STATE OF NORTH CAROLINA
DEPARTMENT OF TRANSPORTATION

Addendum No. 1

RE: Contract ID: C201790

Harnett County (I-4906)

PROJECT NO.	SHEET NO.	TOTAL NO.
I-4906	4	
39994.3.GV1

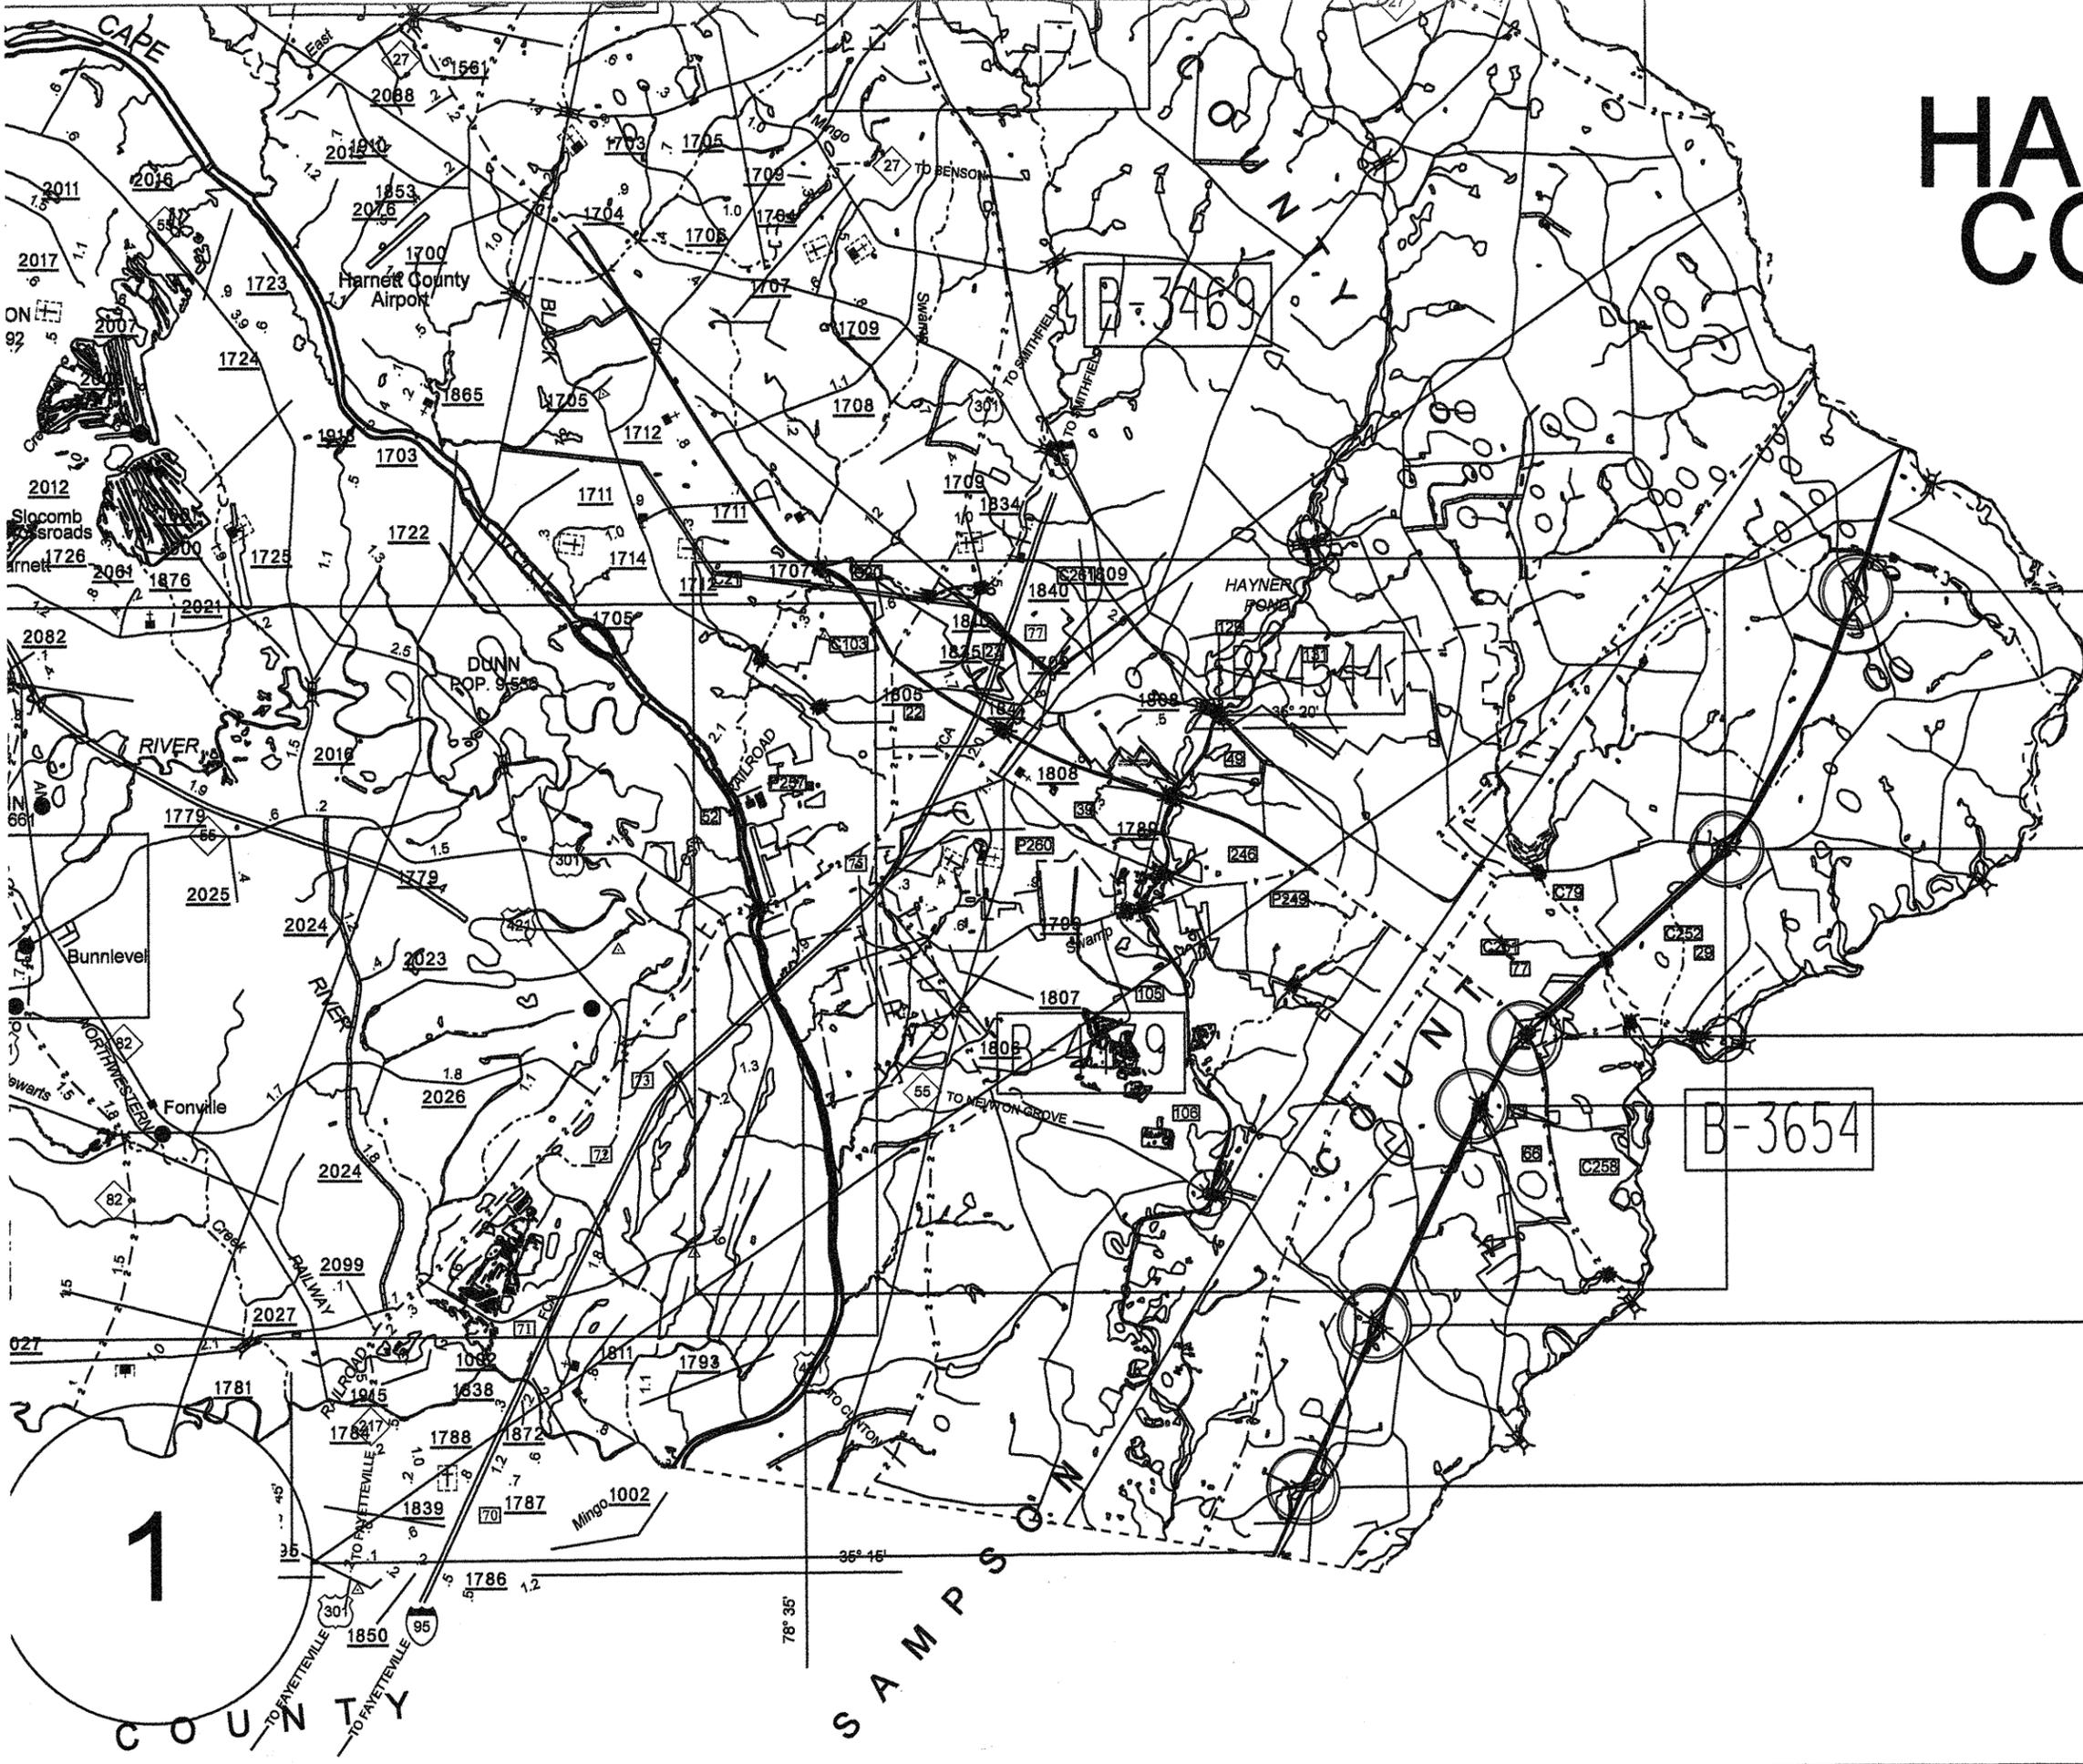
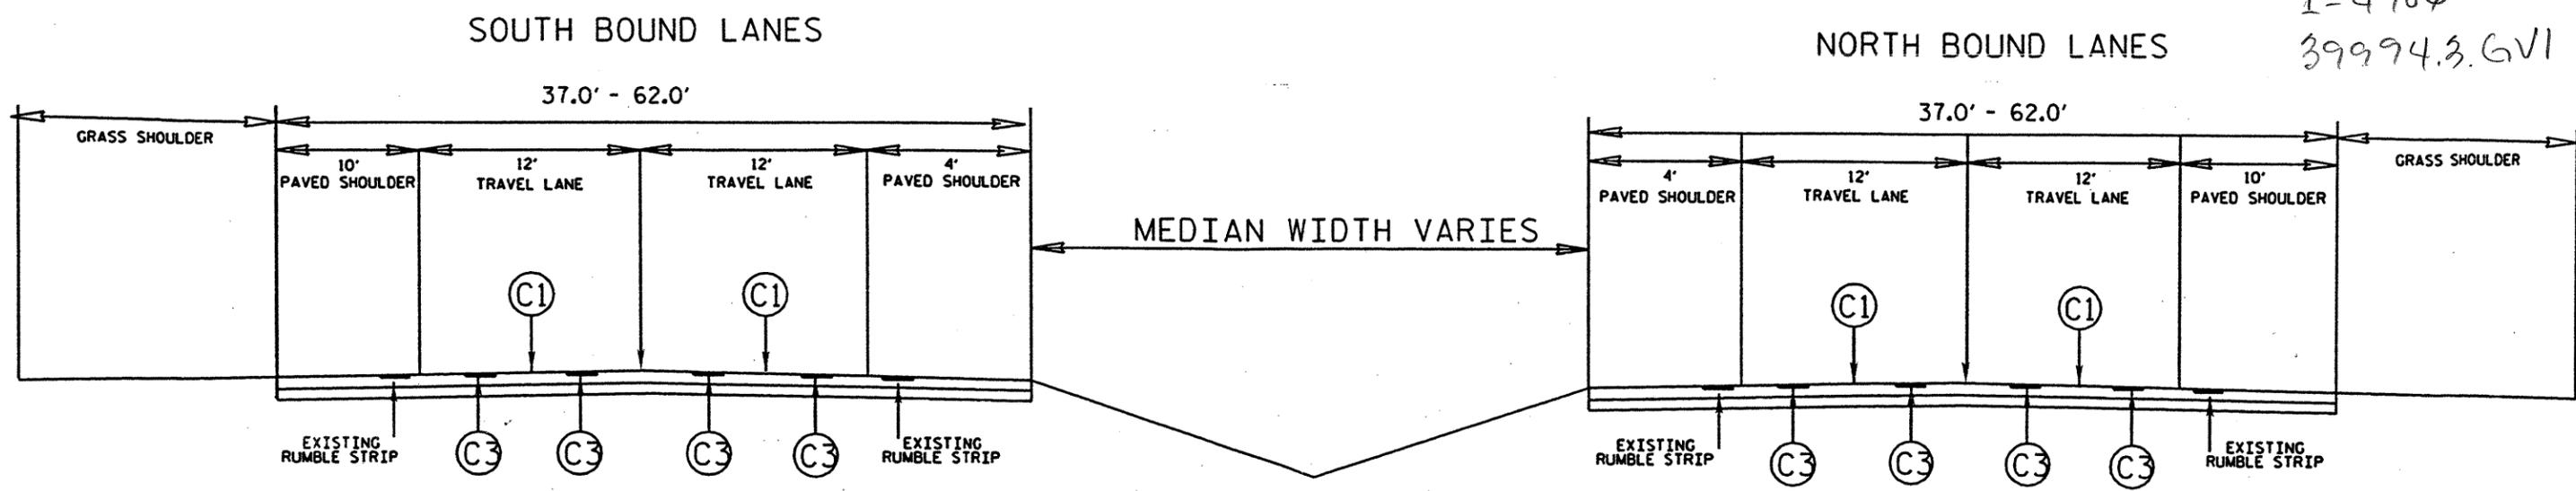
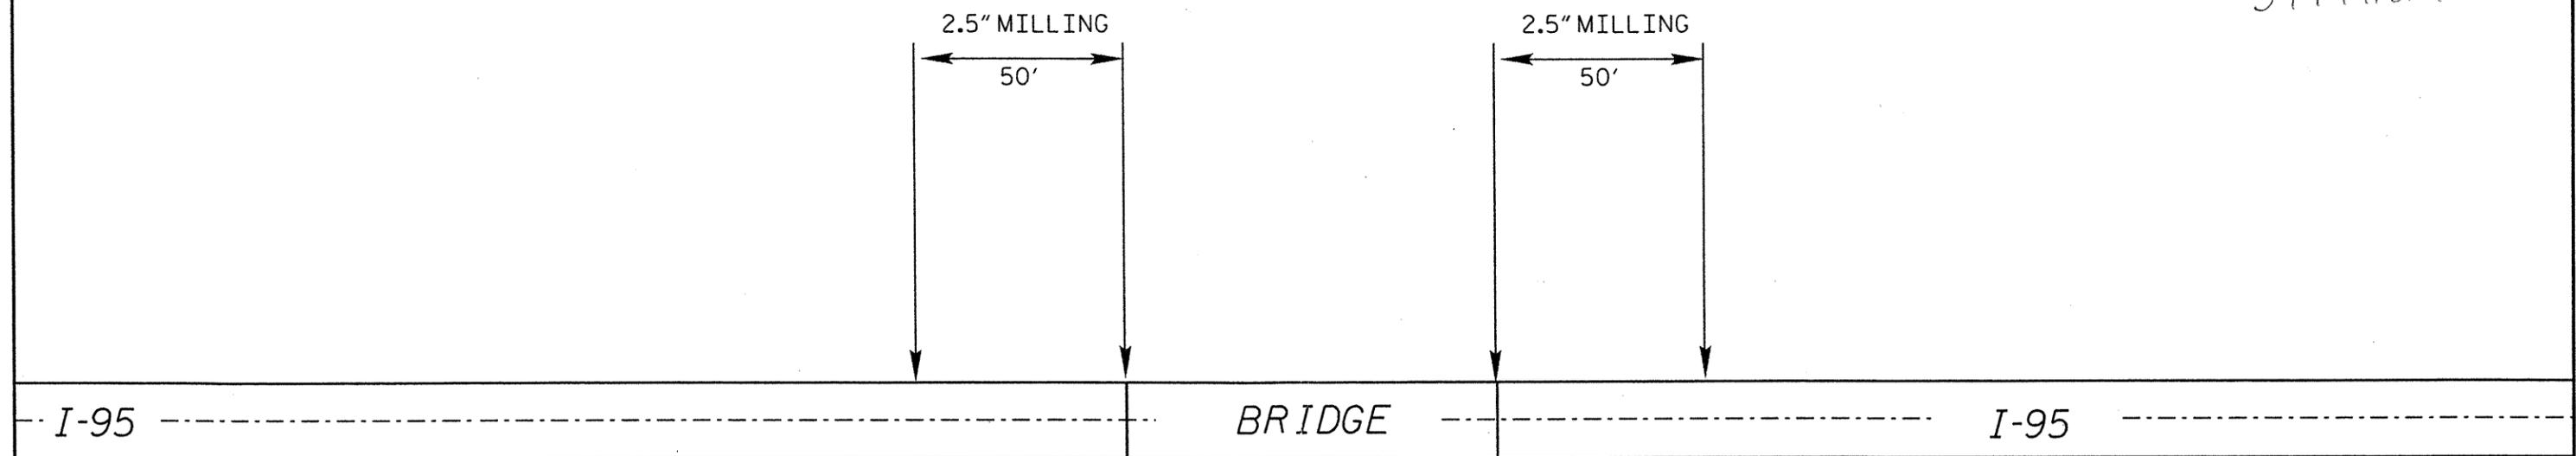
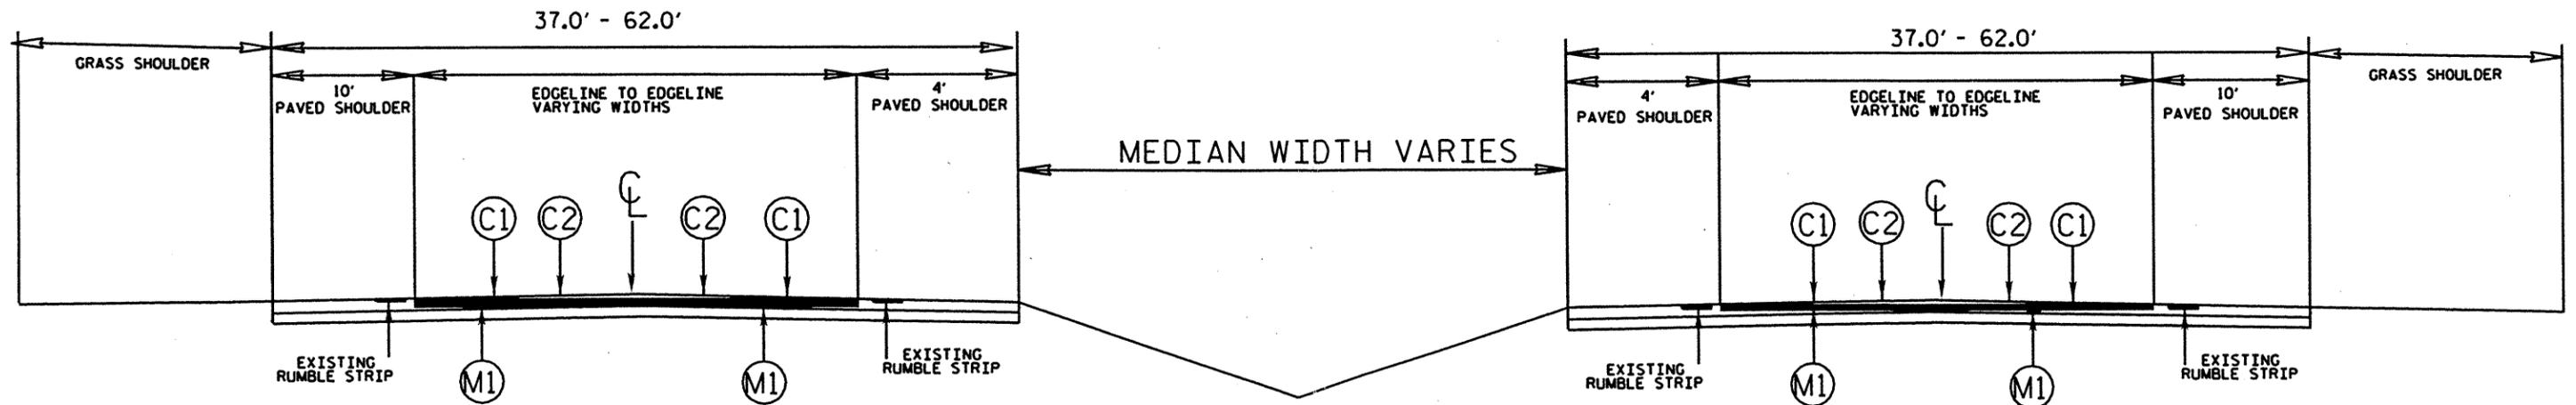
Sheet No. 4 has been revised to include the Pay Item of "Asphalt Binder for Plant Mix Grade PG 70-28". Please void Sheet No. 4 in your Sketch Maps and staple the revised Sheet No. 4 thereto.

<u>New Pay Item</u>		<u>Quantity</u>
29-1567000000-E	Asphalt Binder for Plant Mix Grade PG 70-28	634 Tons
